Consultation Response from KC, Highways Development Management		
2021/90749 Land adj, 105, Highgate Lane, Lepton, Huddersfield, HD8 0HQ		
Demolition of detached garage and conservatory and erection of two detached dwellings and associated landscaping		
Date Responded: 11/05/2021	Responding Officer: Zack Turner	Responding Ref: K11-18SW/2

2021/90749

Highways Development Management (HDM) comments as follows.

Drg. no.	Rev.
001-21-PL01	A

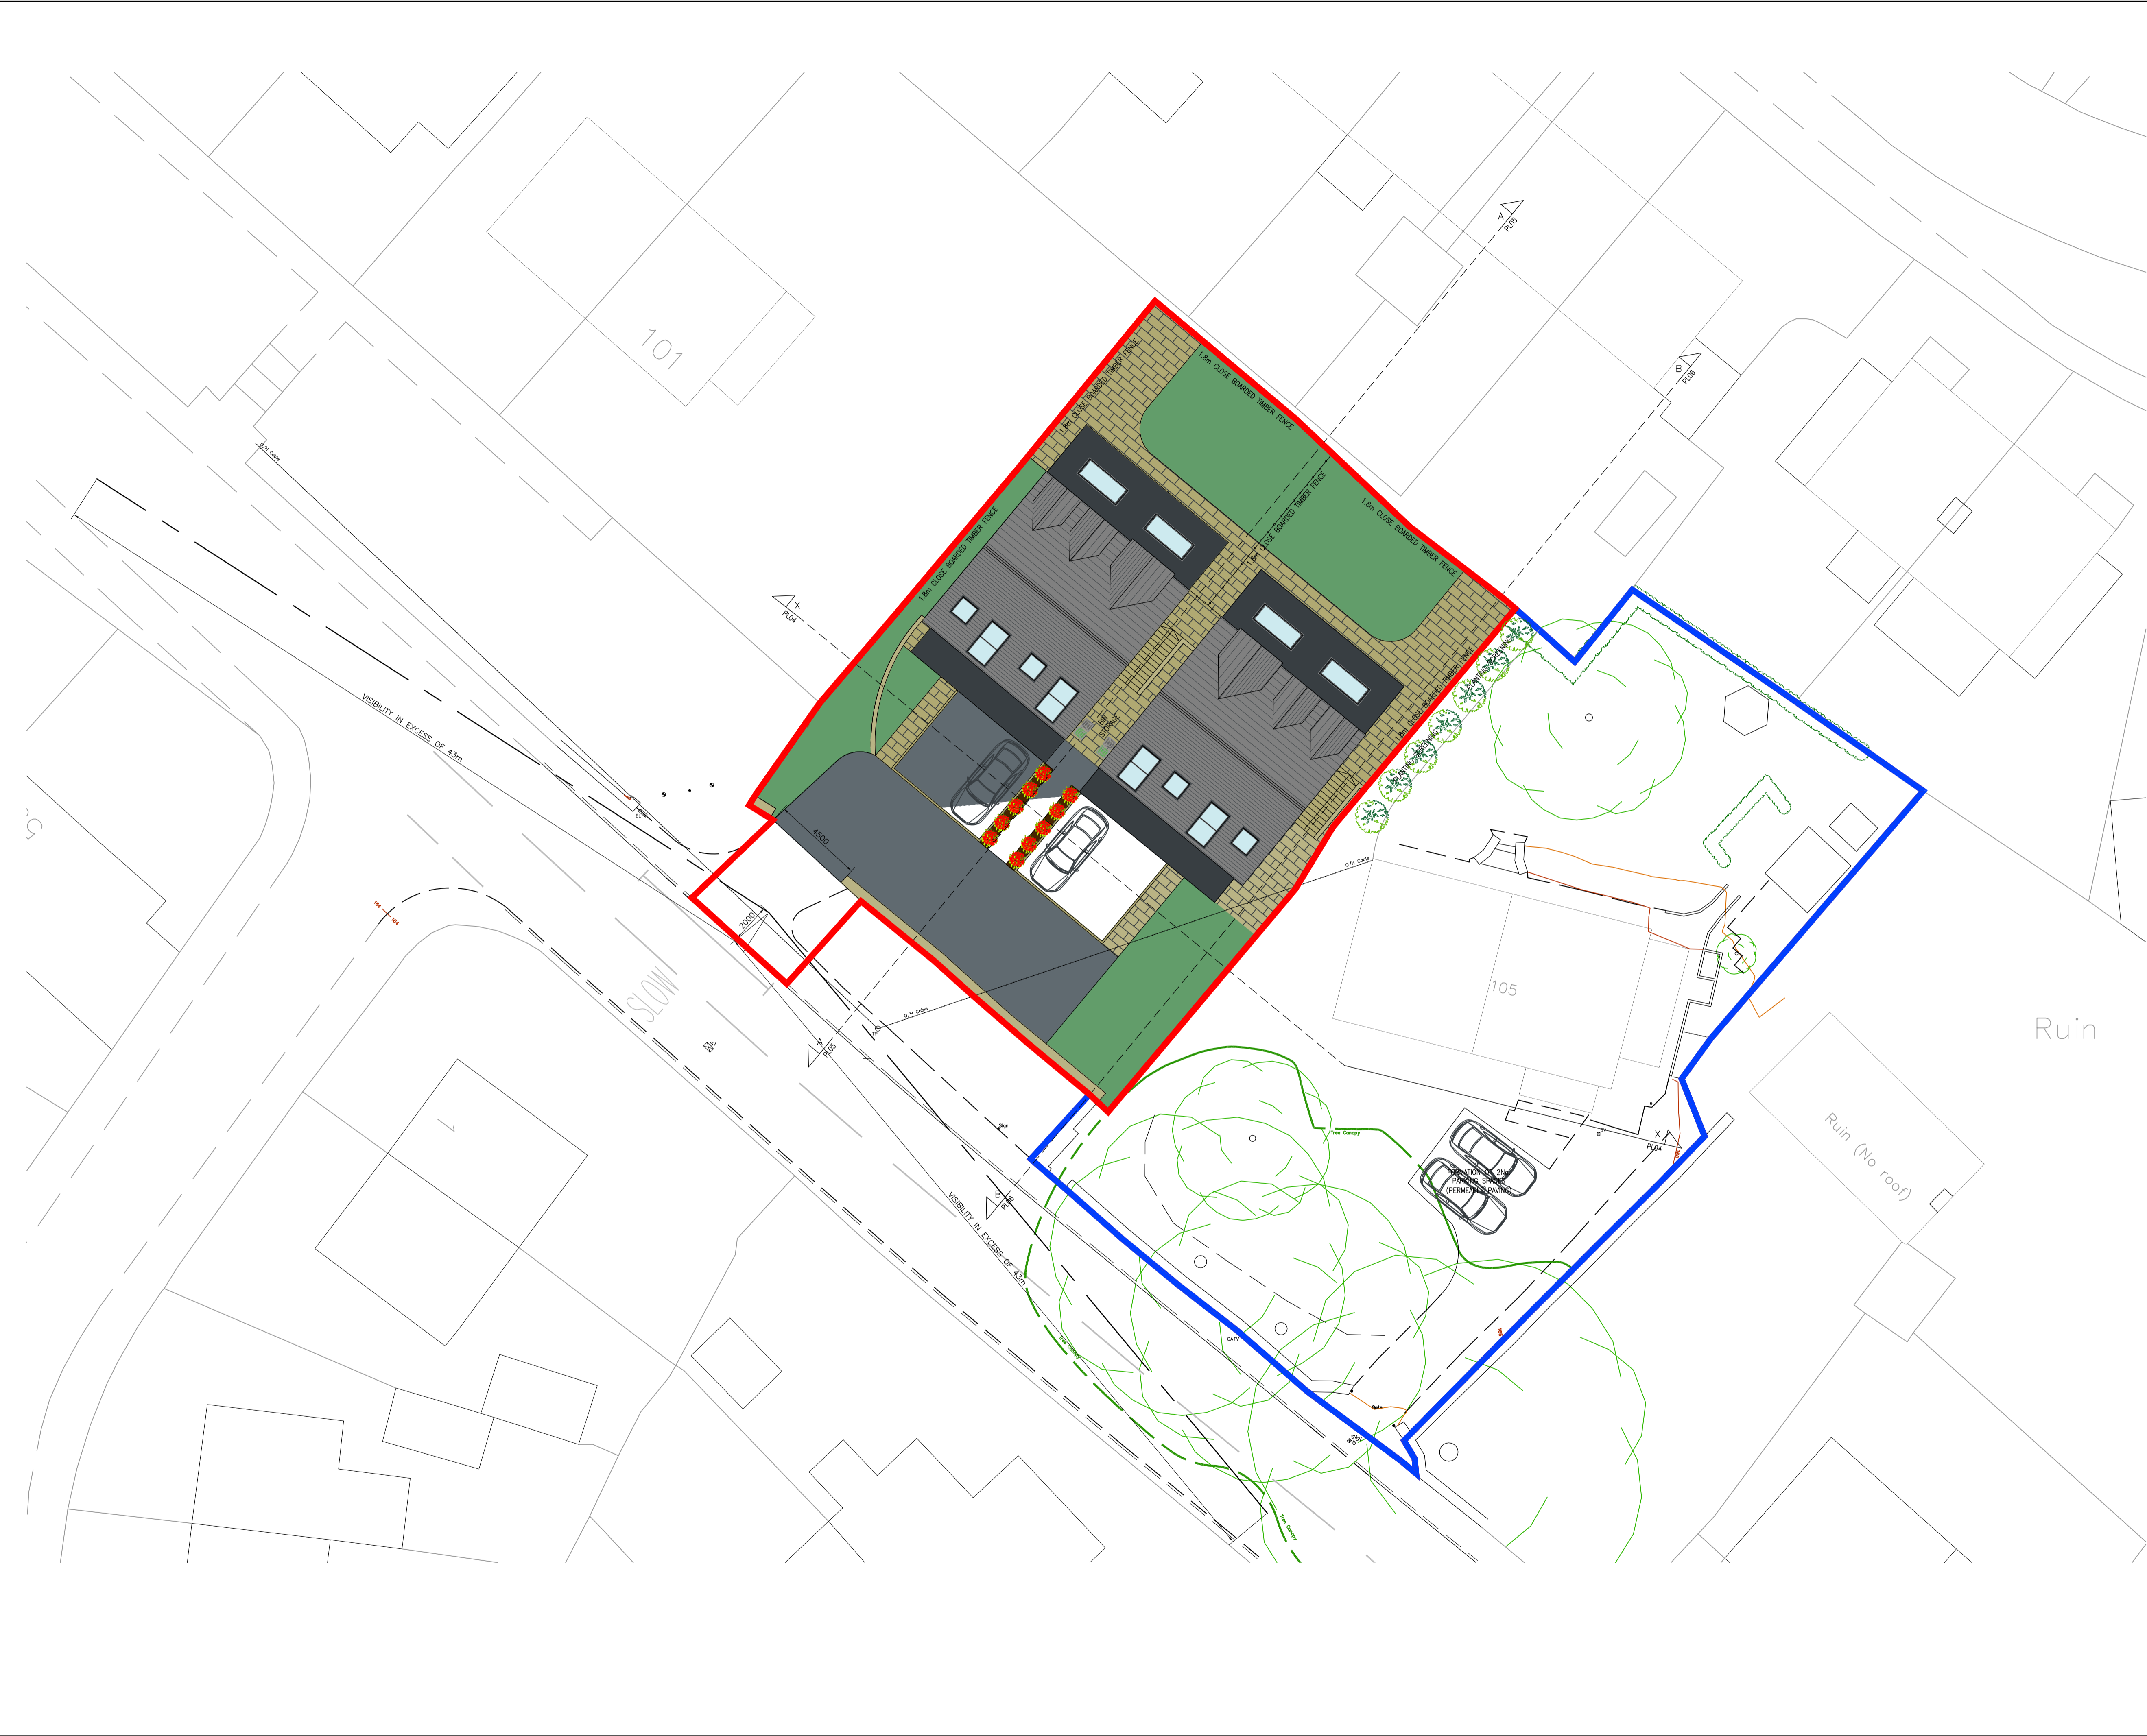
The new dwellings will utilize the existing access that was previously used for the current dwelling. The existing dwelling will now also utilize an existing access from Highgate Lane which appears to not have been in use for vehicles due to the other access for the old, detached garage.

The access for the new dwelling is being widened to 4.5m to allow for 2-way movement.

Visibility splays have been demonstrated and these are good as they are in excess of 43m in both directions for the 30mph road.

The demolition of the double garage will result in the loss of 2 parking spaces for the existing 3-bedroom dwelling however, this is being replaced by creating 2 new spaces towards the front of the dwelling.

There is an area within the site of the existing dwelling to reverse into the new parking spaces and exit the site in forward gear.

The 2 new dwellings will both have 4 bedrooms and sufficient parking is being provided by an integral double garage with space in front for an additional 2 parking spaces for each dwelling.

Bin storage for the new dwellings has been presented in a suitable location between the houses and bin storage for the existing dwelling will remain unaltered.

Highways Development Management consider sufficient parking is provided for both dwellings and therefore believes the proposal is acceptable with the following condition.

Areas to be surfaced and drained

Unless otherwise agreed in writing, prior to the development being brought into use, the approved vehicle parking areas shall be surfaced and drained in accordance with the Communities and Local Government; and Environment Agencies 'Guidance on the permeable surfacing of front gardens (parking areas)' published 13th May 2009 (ISBN 9781409804864) as amended or superceded; and thereafter retained throughout the lifetime of the development.
